## Application for a Non-Material Amendment Following a Grant of Planning Permission

Hayward Smart Amended Plan - April 2022

20/01353/FUL

Client	Mrs H. Mc Neill	
Project	The Martins Broadwell	
Drawing	Proposals Sketch Scheme 1	
Date	April 20	
Scale	1:100 at A1	Drawn SH
Job No	19-110	Drawing No 04E

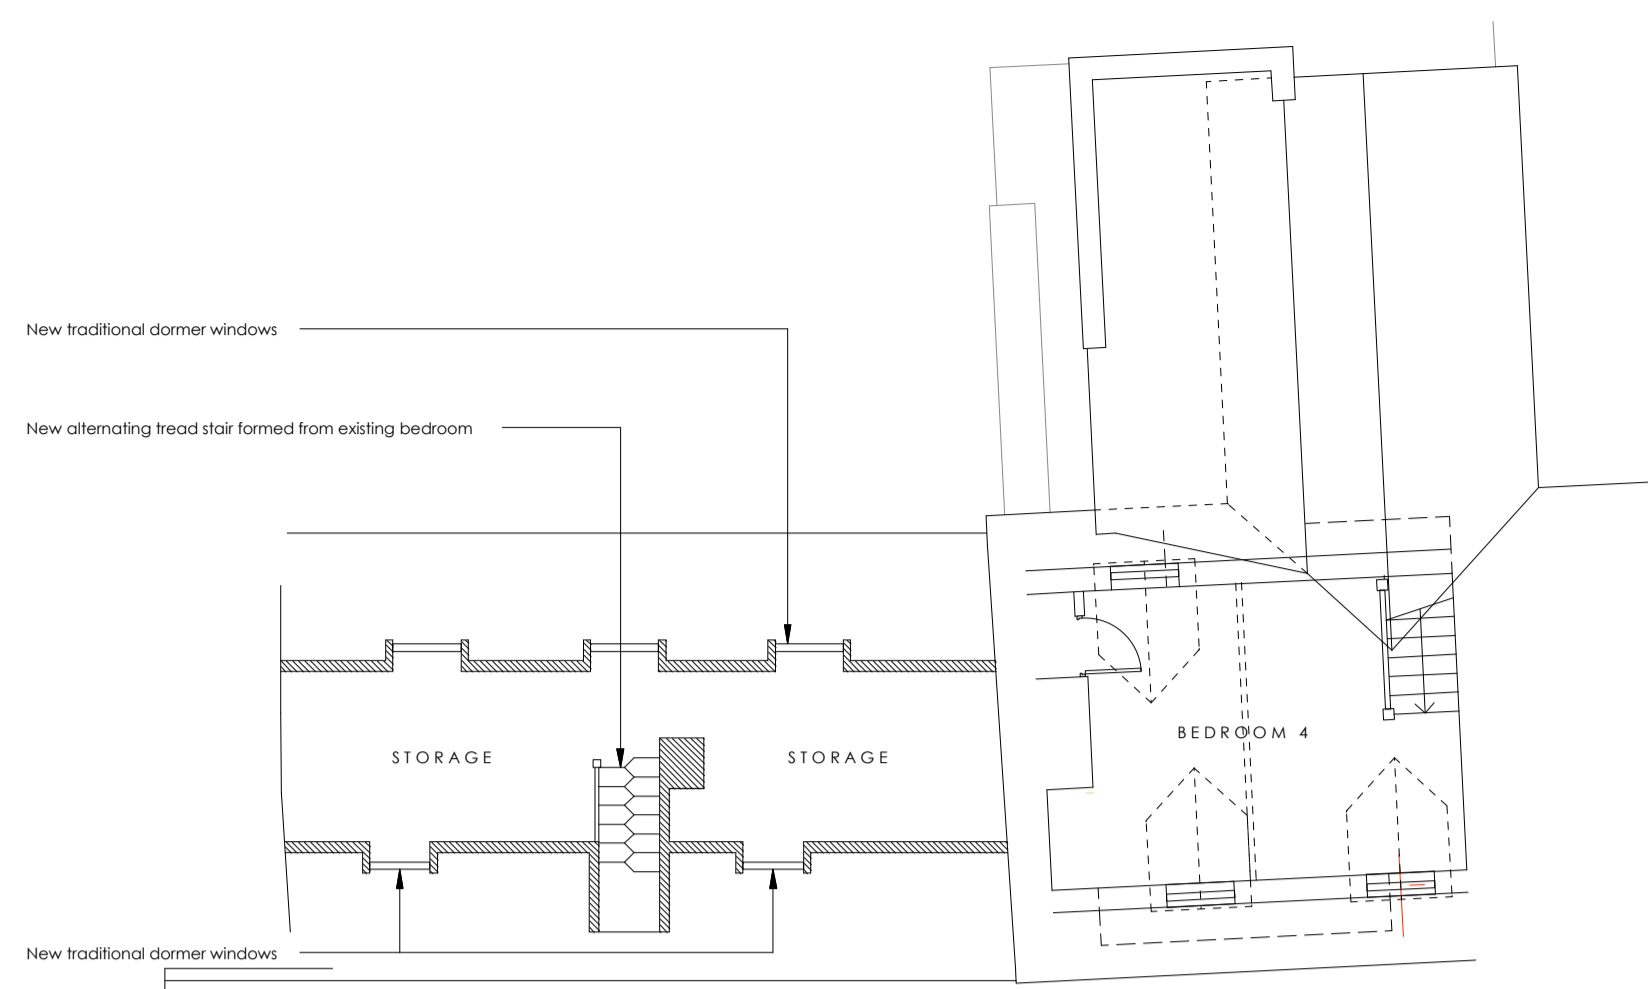
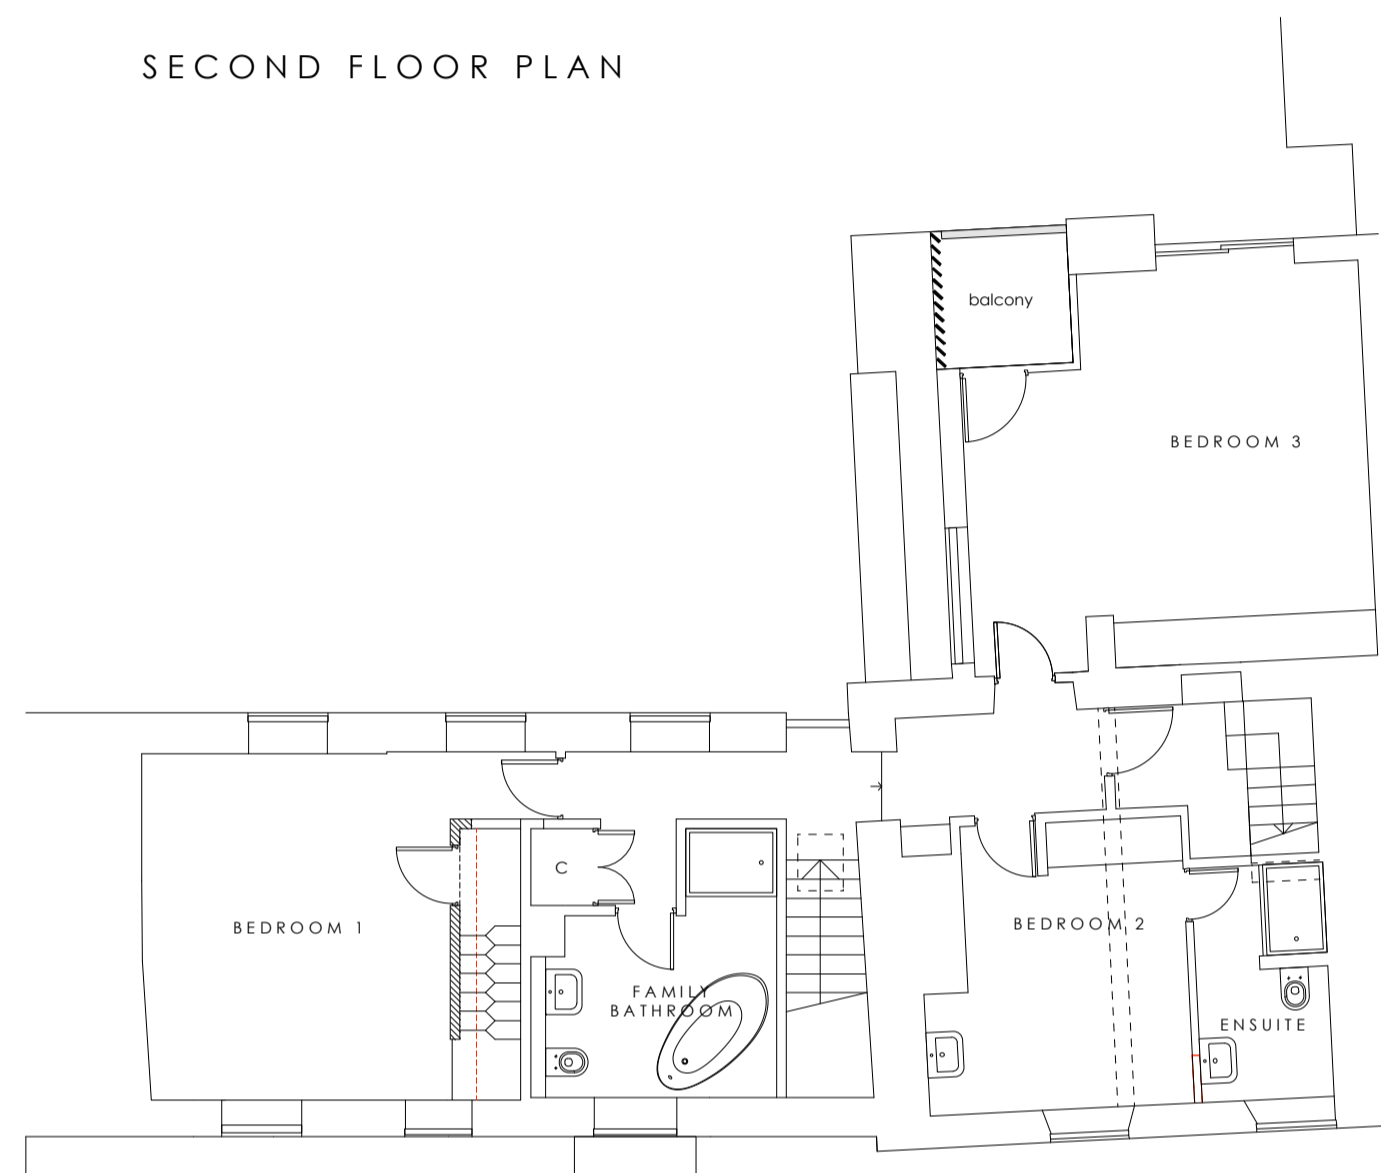
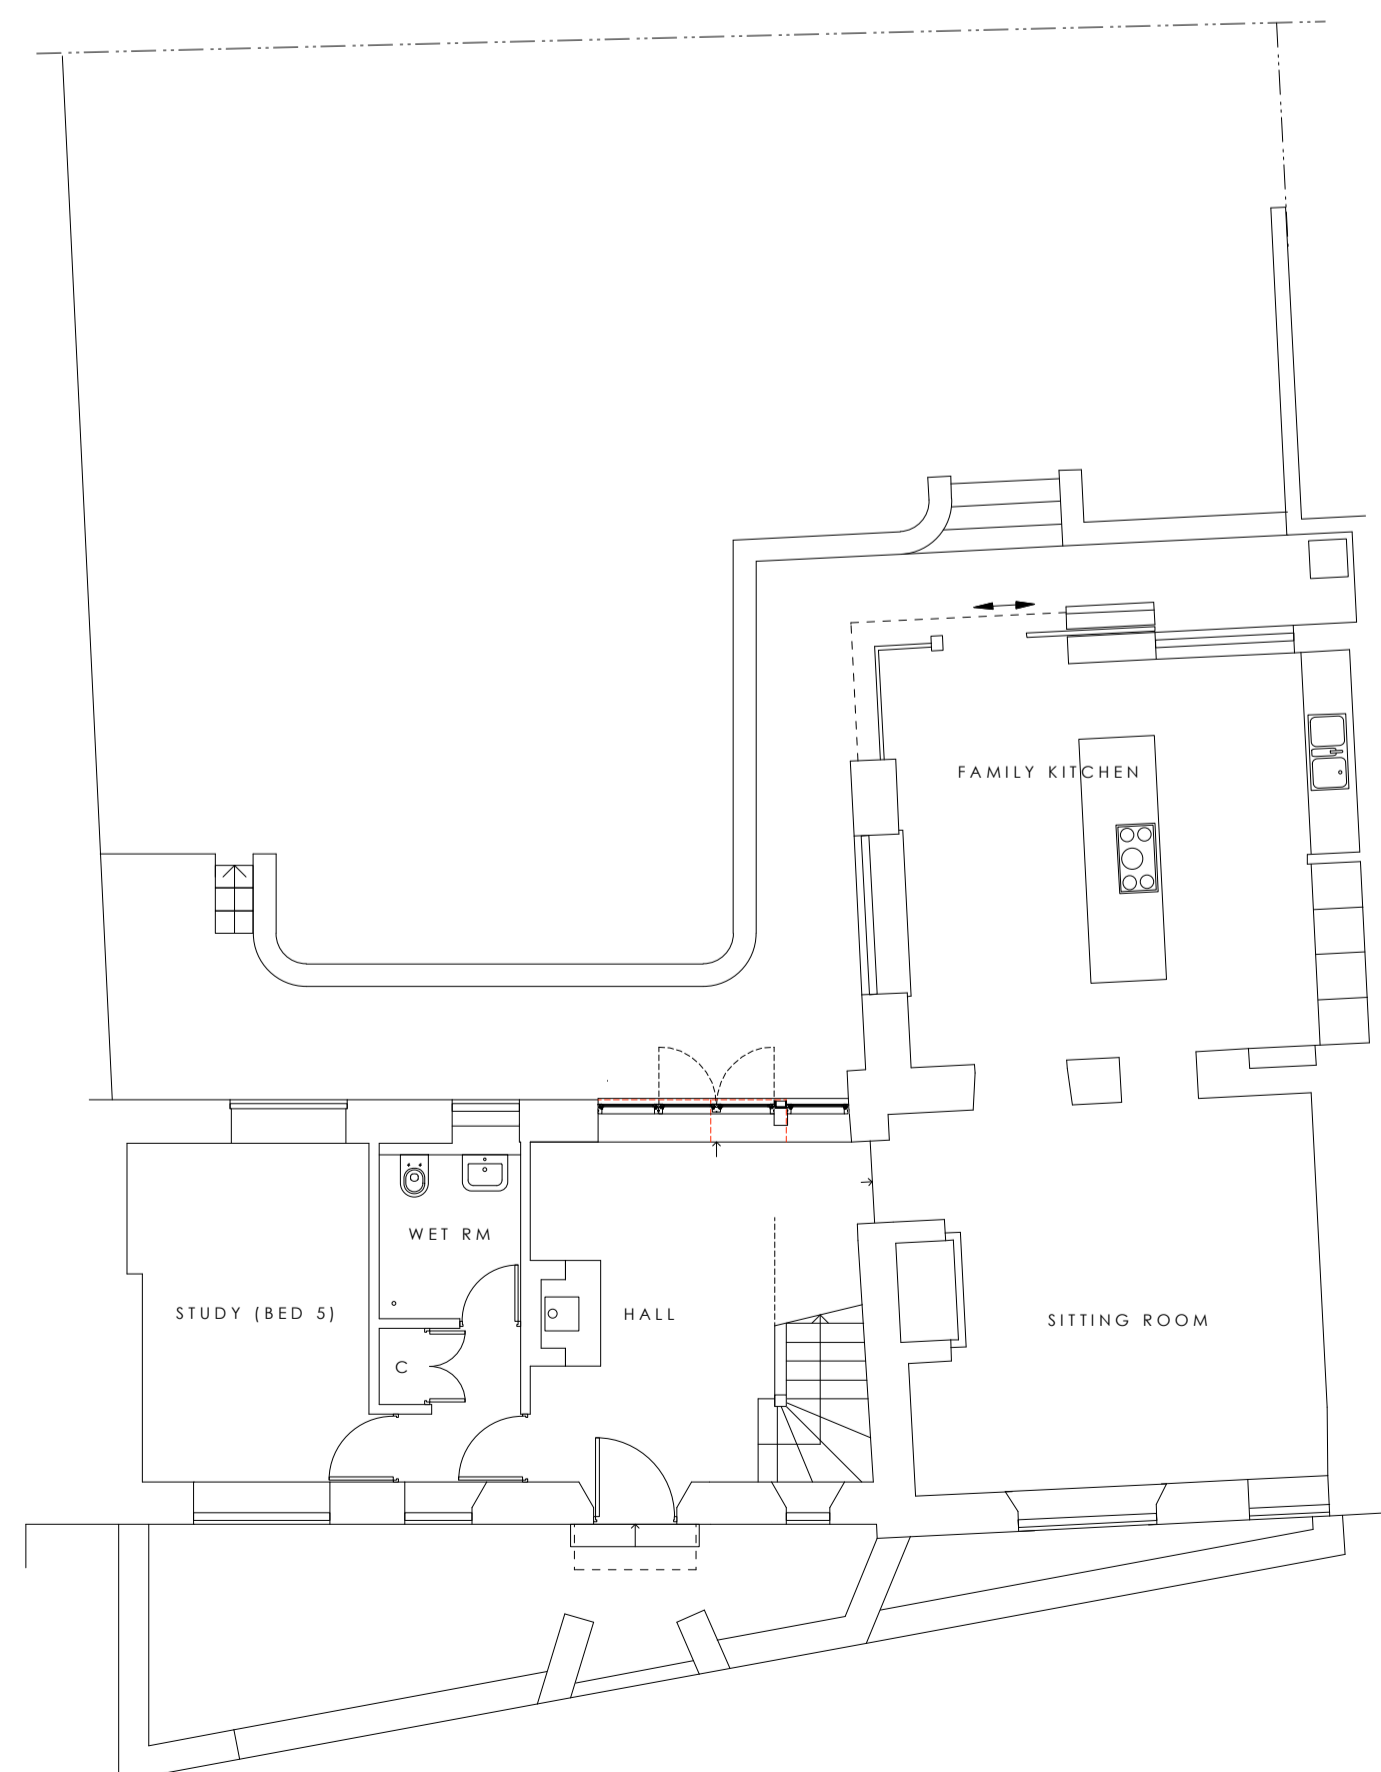
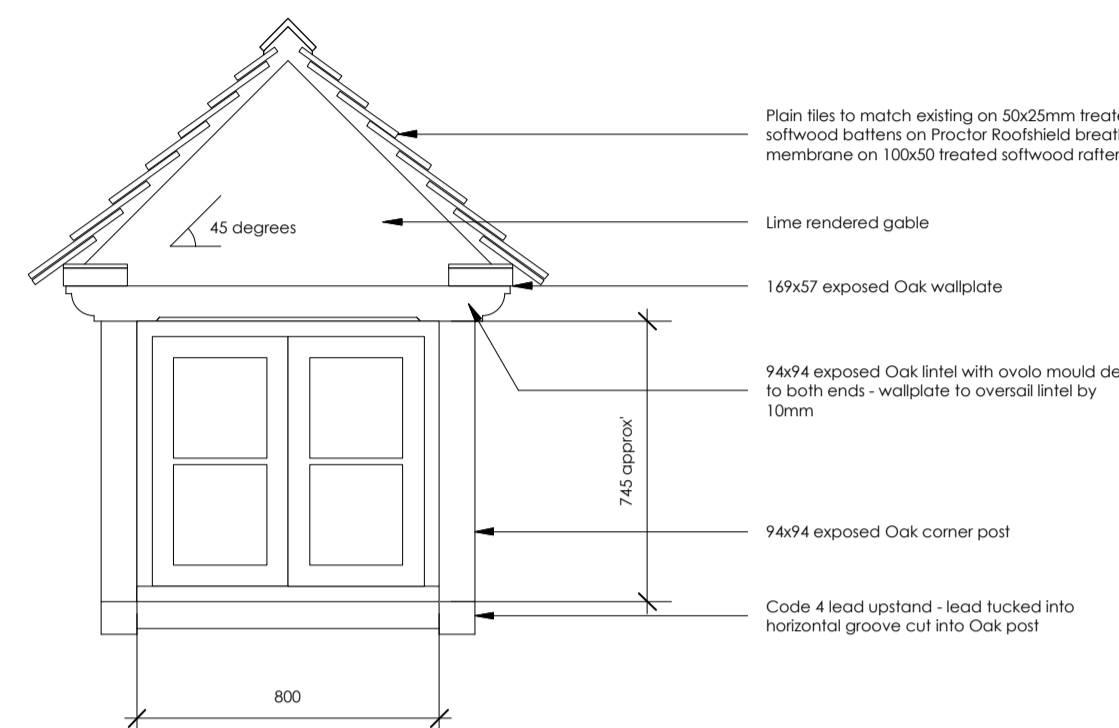
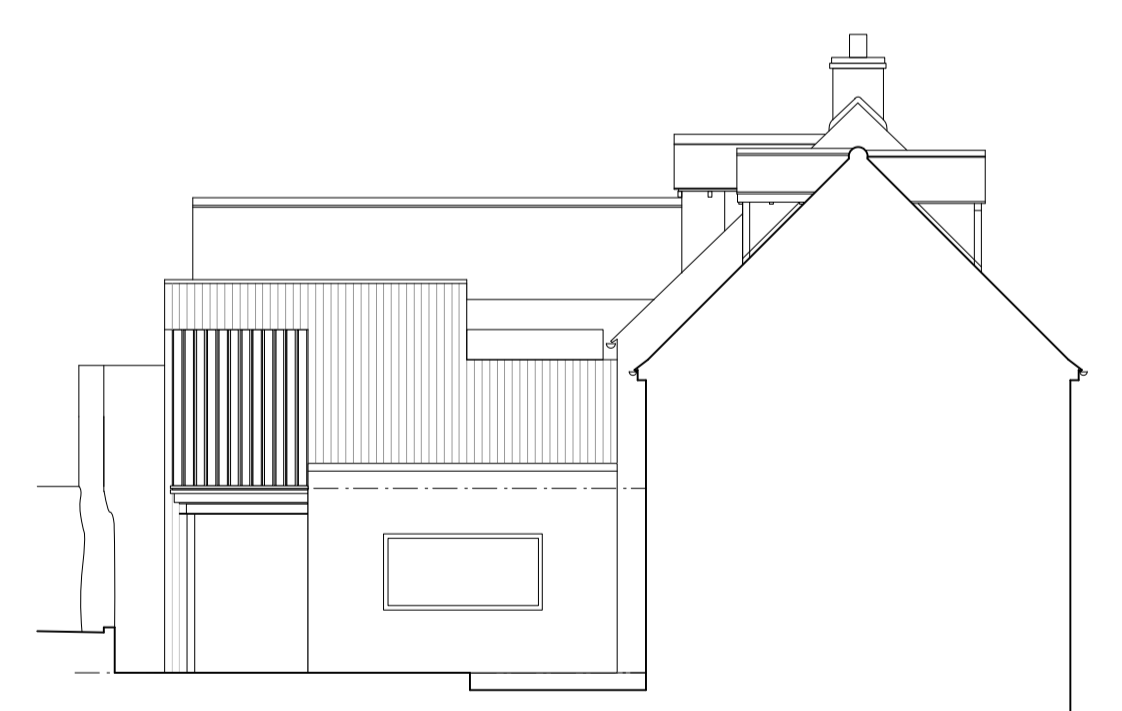
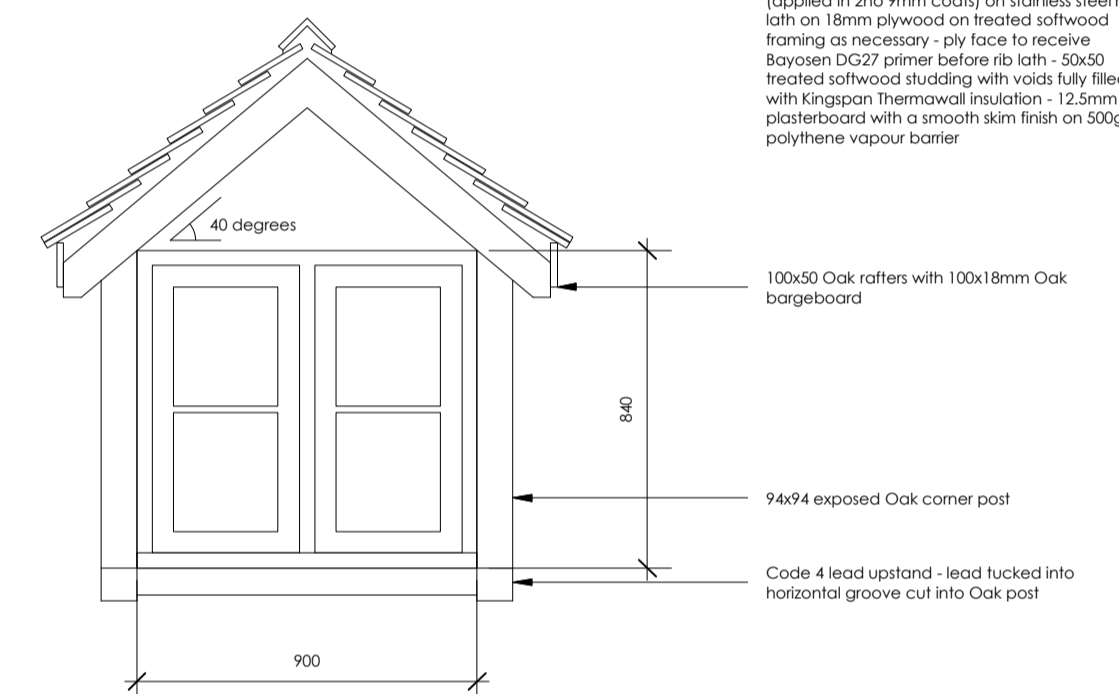
Following on from what I have said below [above] - I have also noticed that the plans which are listed in the condition state the lead material for the dormer windows. Therefore, this obviously doesn't match up with the condition to say the new dormer material should match those on the existing building. Therefore, provided the render material does match those on the existing property, I think you could submit a non-material amendment application to change the materials on the plans (you should annotate on the plans the correct materials) and provide a photo to show how the new materials will match those on the existing property.
